Application by Highways England for an order granting development consent for the M25 Junction 10/A3 Wisley Interchange improvement project

Submission made pursuant to Deadline 5

3a. Visibility splays drawings (REP4-006)

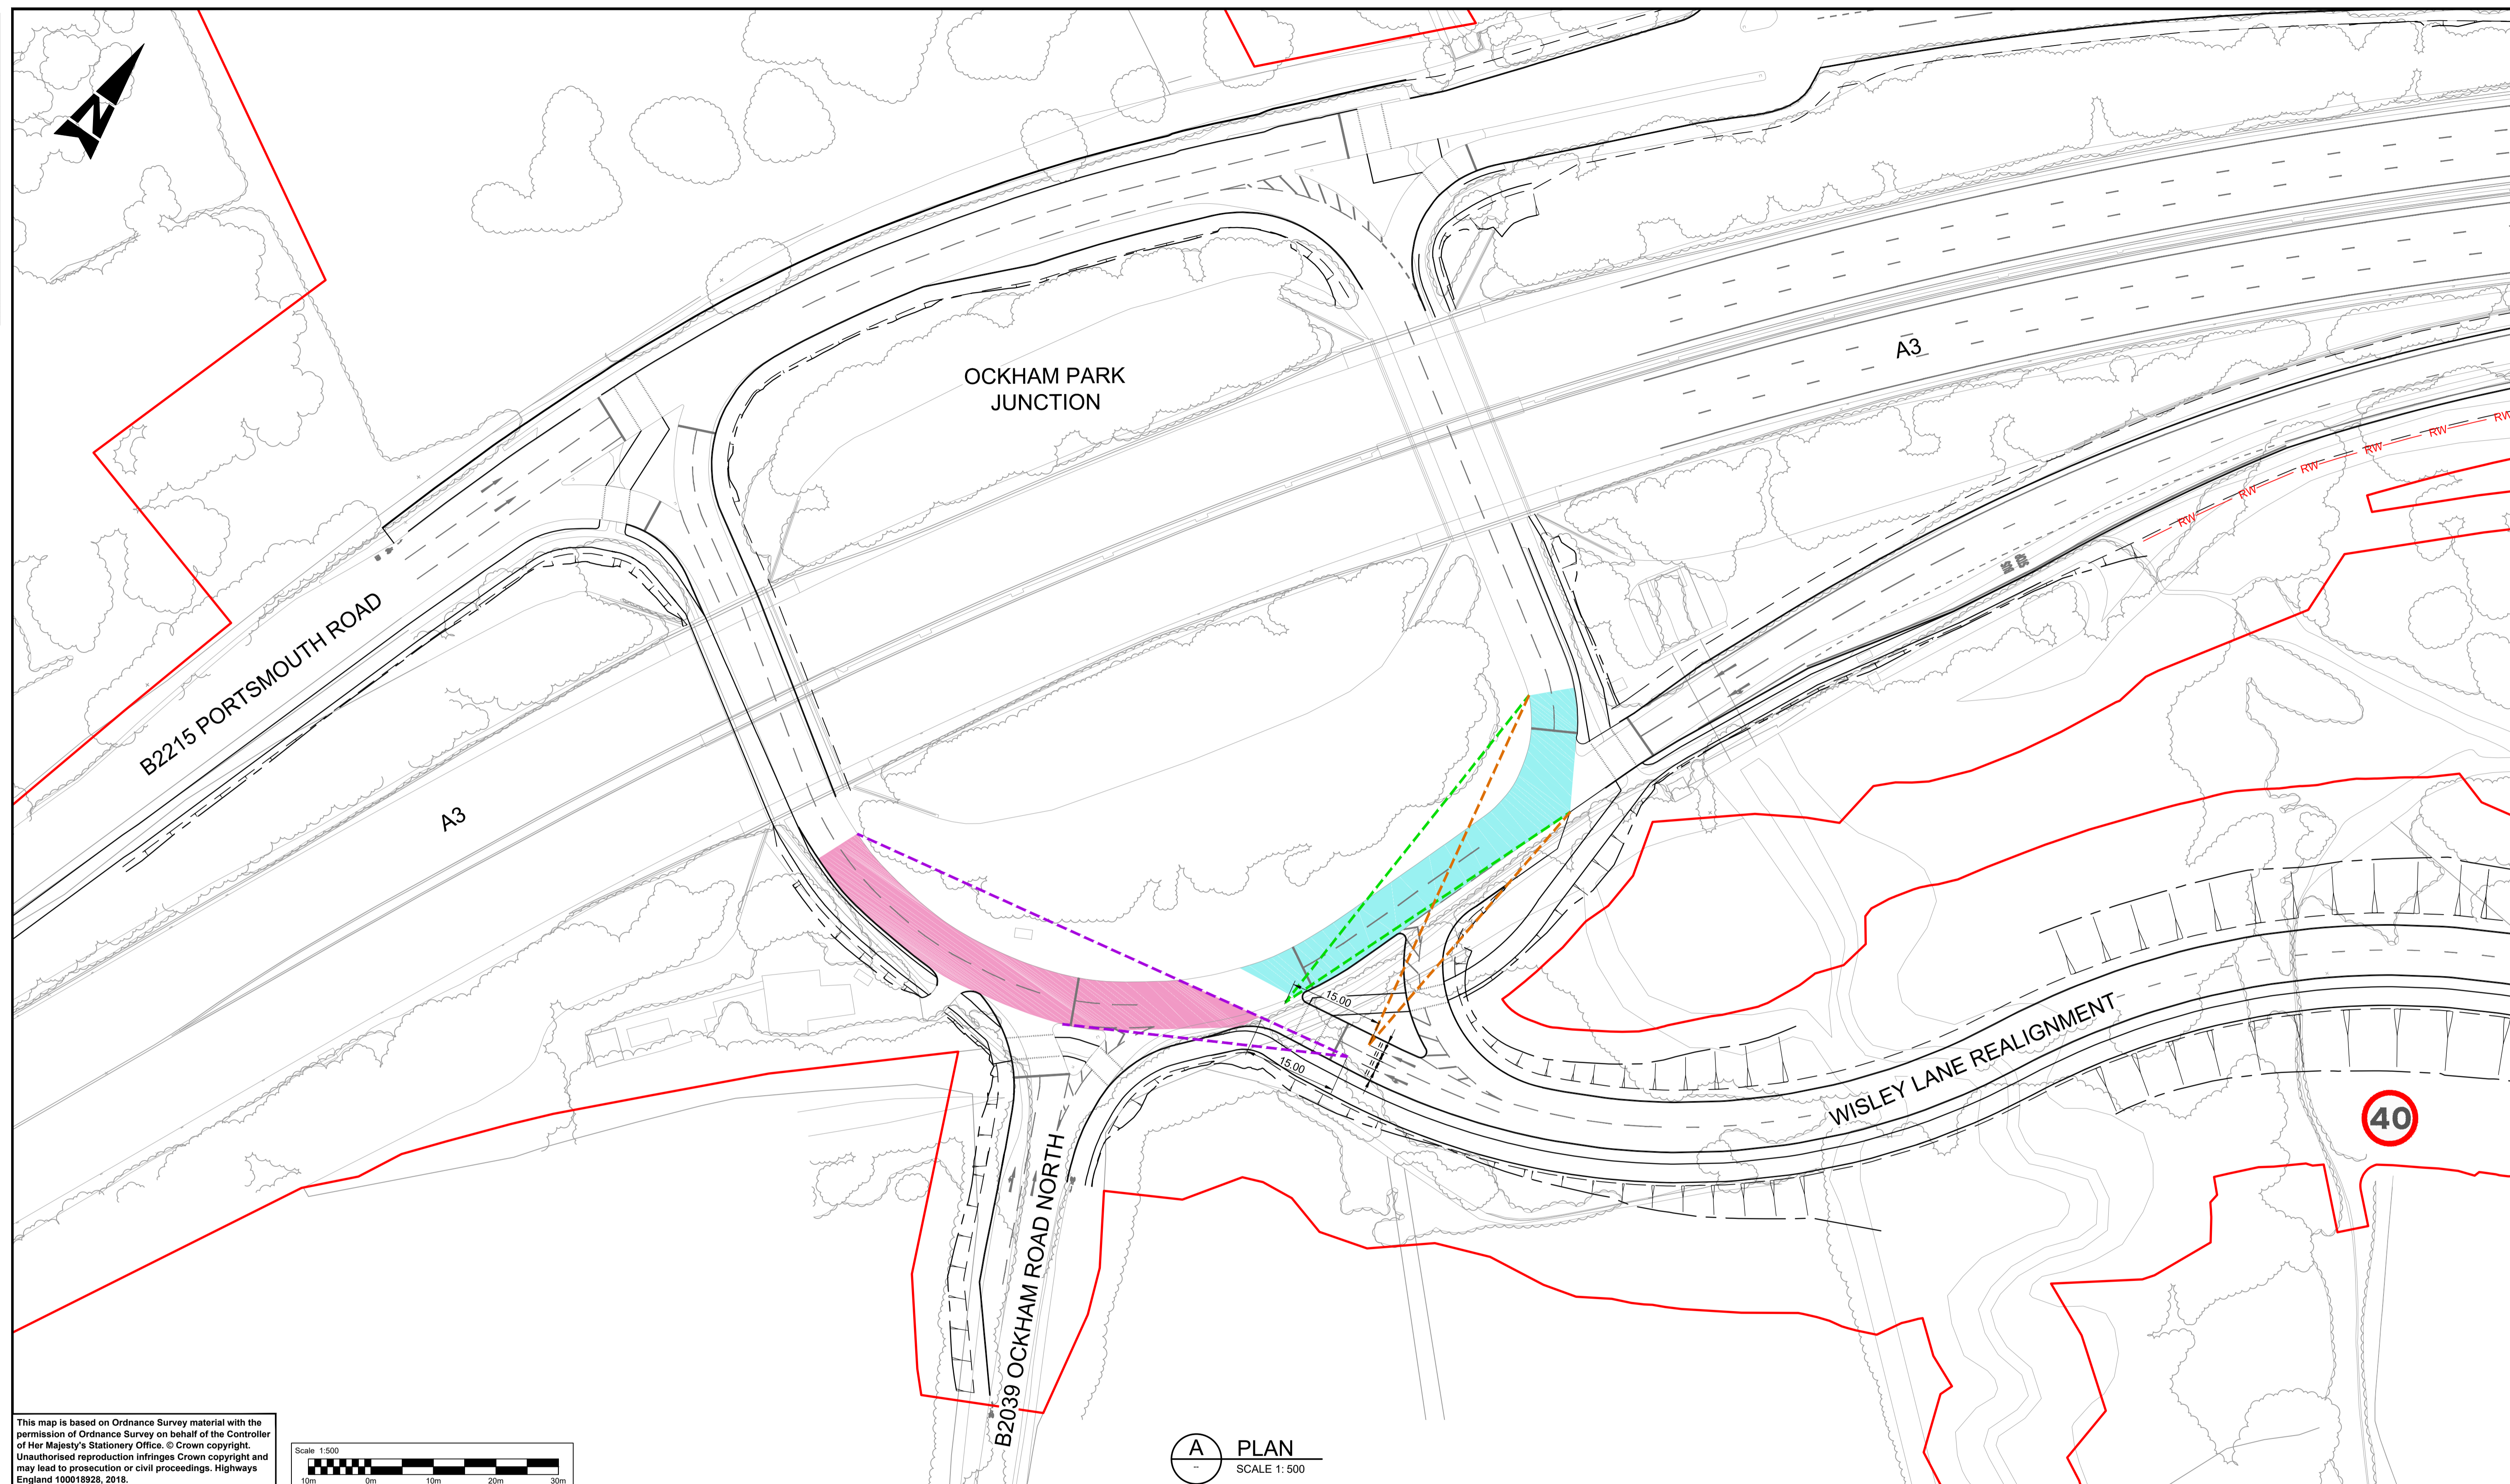
Wisley Lane forward visibility	The drawing submitted within REP4-006 did not correctly show the required forward visibility for the 30mph speed limit. HE advise that a revised drawing will be submitted at deadline 5.

A3/A245 PAINSHILL JUNCTION

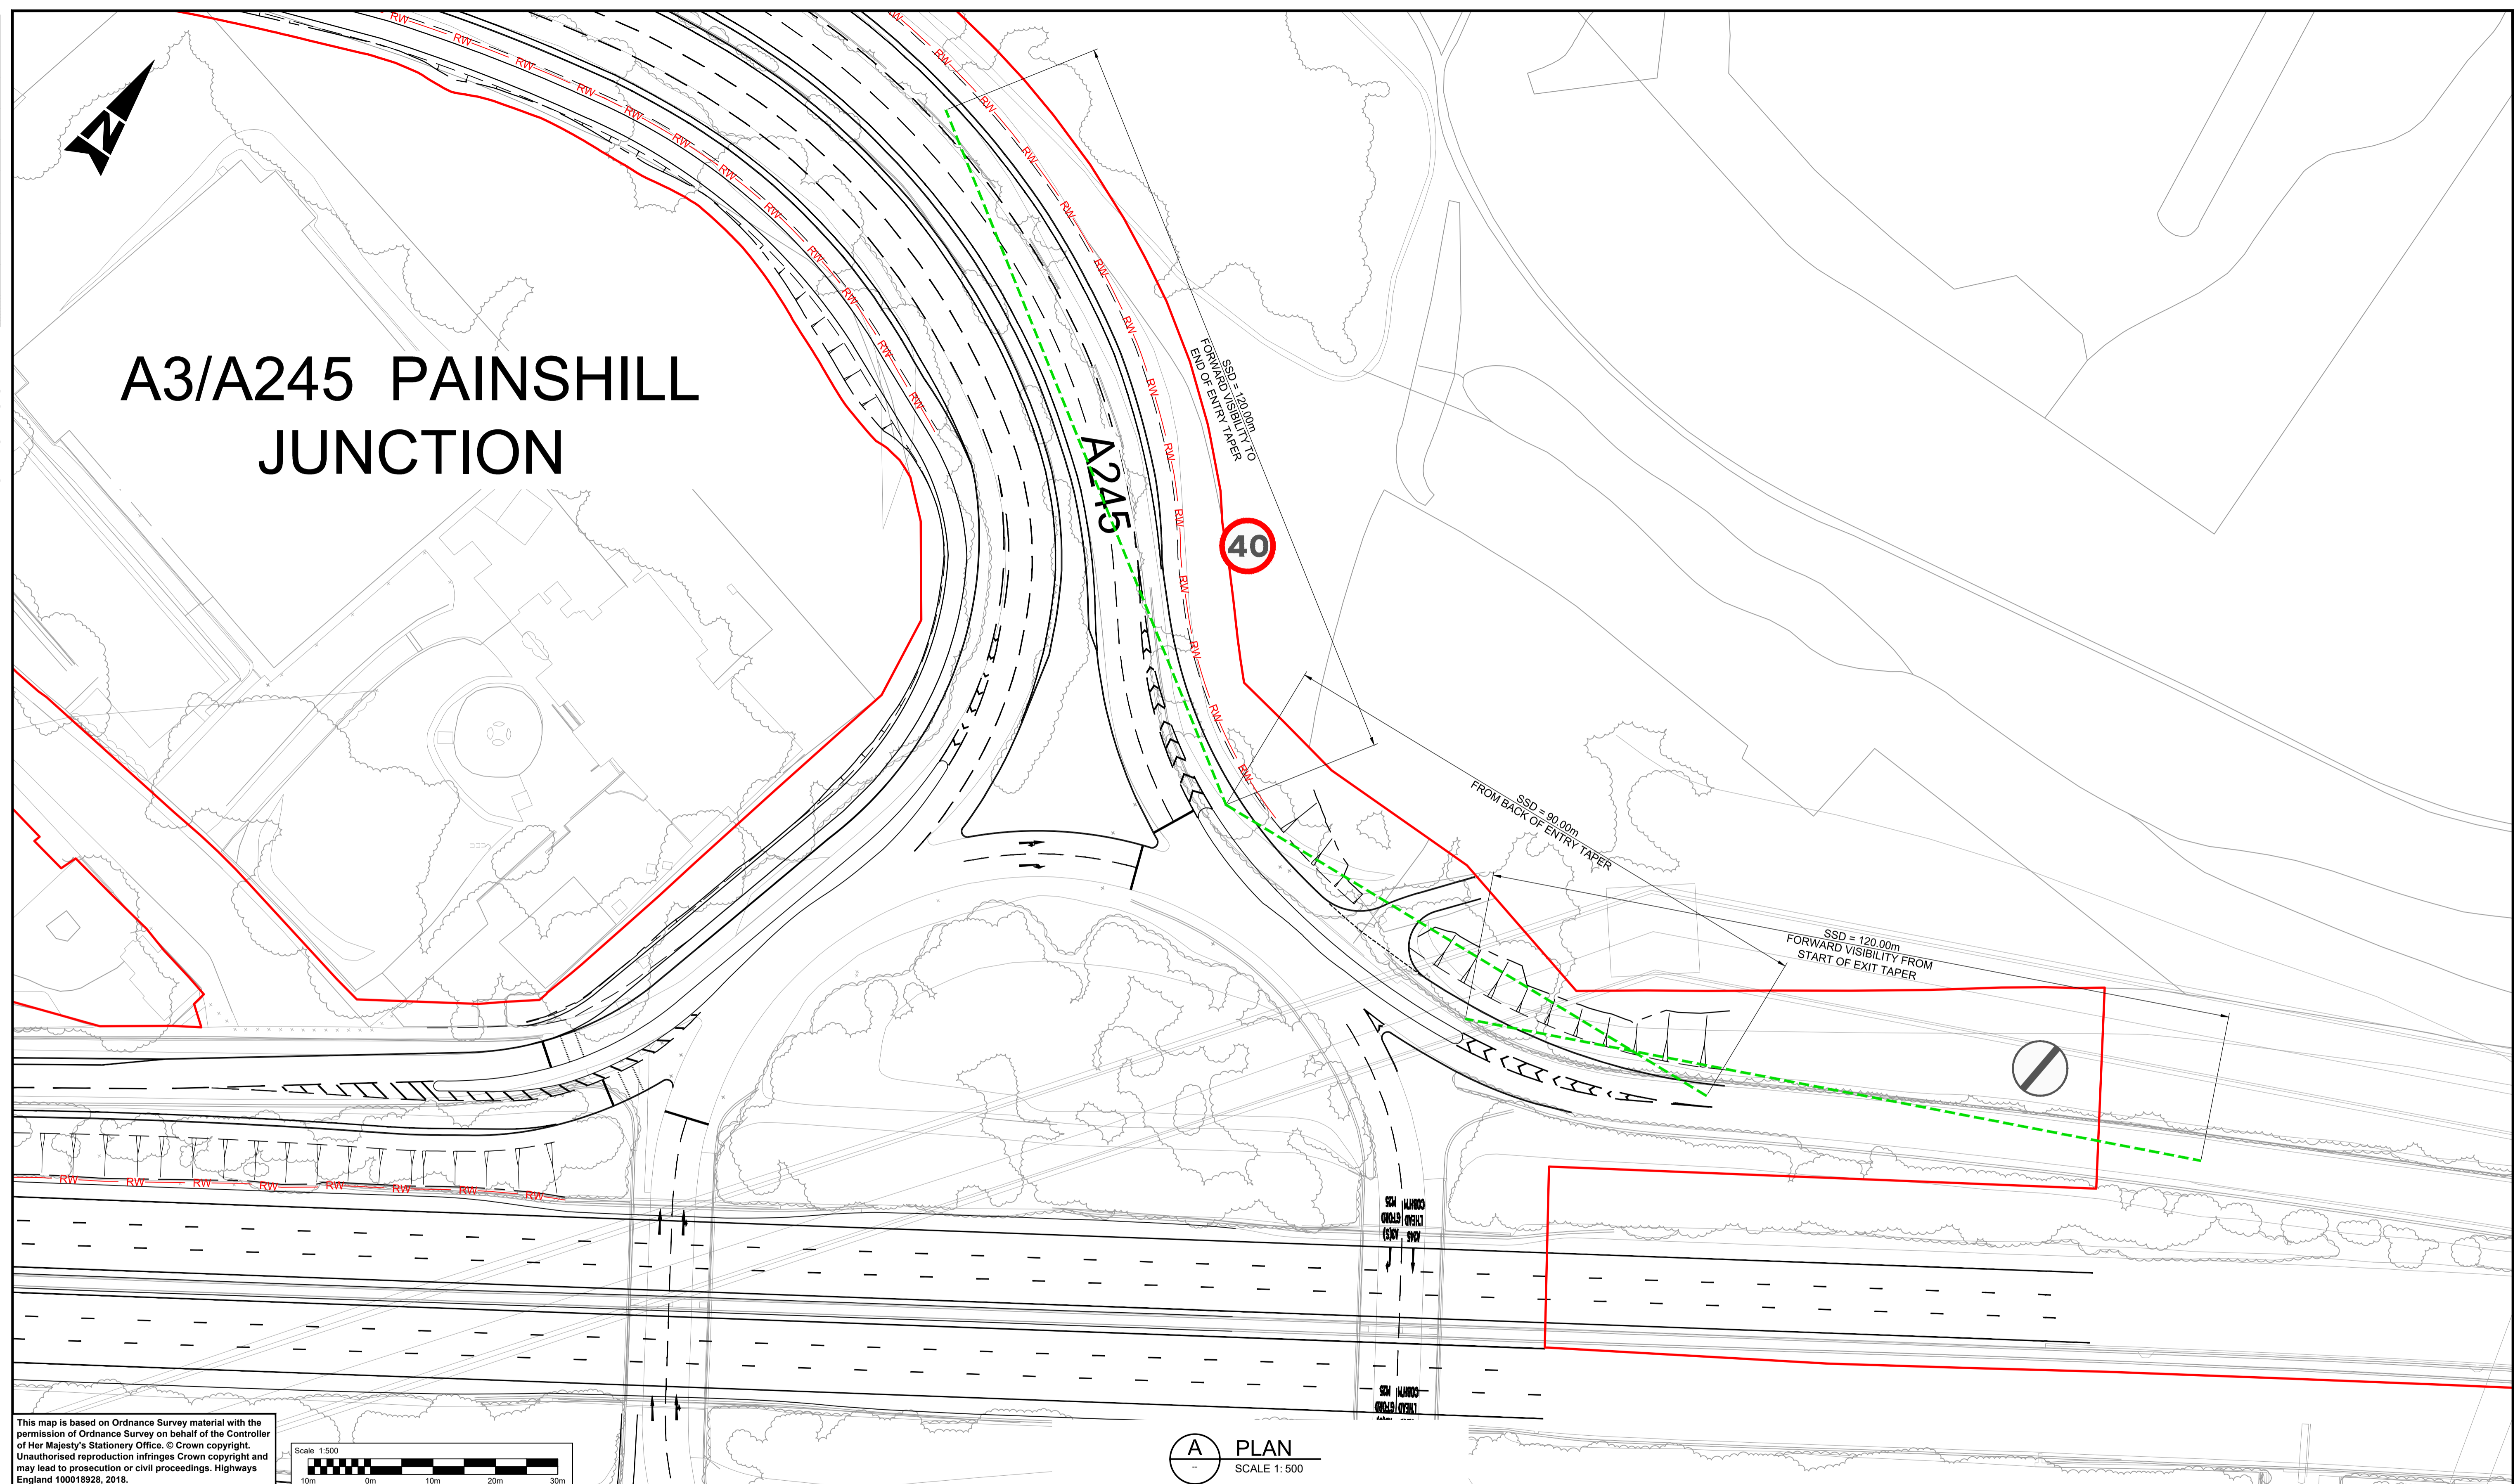
Location	Issue identified
Old Lane/Elm Lane junction	The County Council's response to the drawings provided is included at ExA Q2.13.30.
Painshill northbound off to westbound A245	<p>SCC have great concerns about the junction of A3 London Bound off slip at Painshill, in terms of the forward visibility around the express lane into Seven Hills Road. SCC query whether there is mitigation that can provide for the potential safety issues here.</p> <p>A departure will be required at this location. Surrey County Council are of the view that approval for any departure should be agreed through the DCO examination process.</p> <p>The County Council also has concerns that a number of SCC trees will be impacted at this location, either through impacting root protection areas or as removal will be required. SCC has not seen the tree survey area or tree protection plans referenced in the scheme arboricultural assessment to understand the impact in this area.</p>
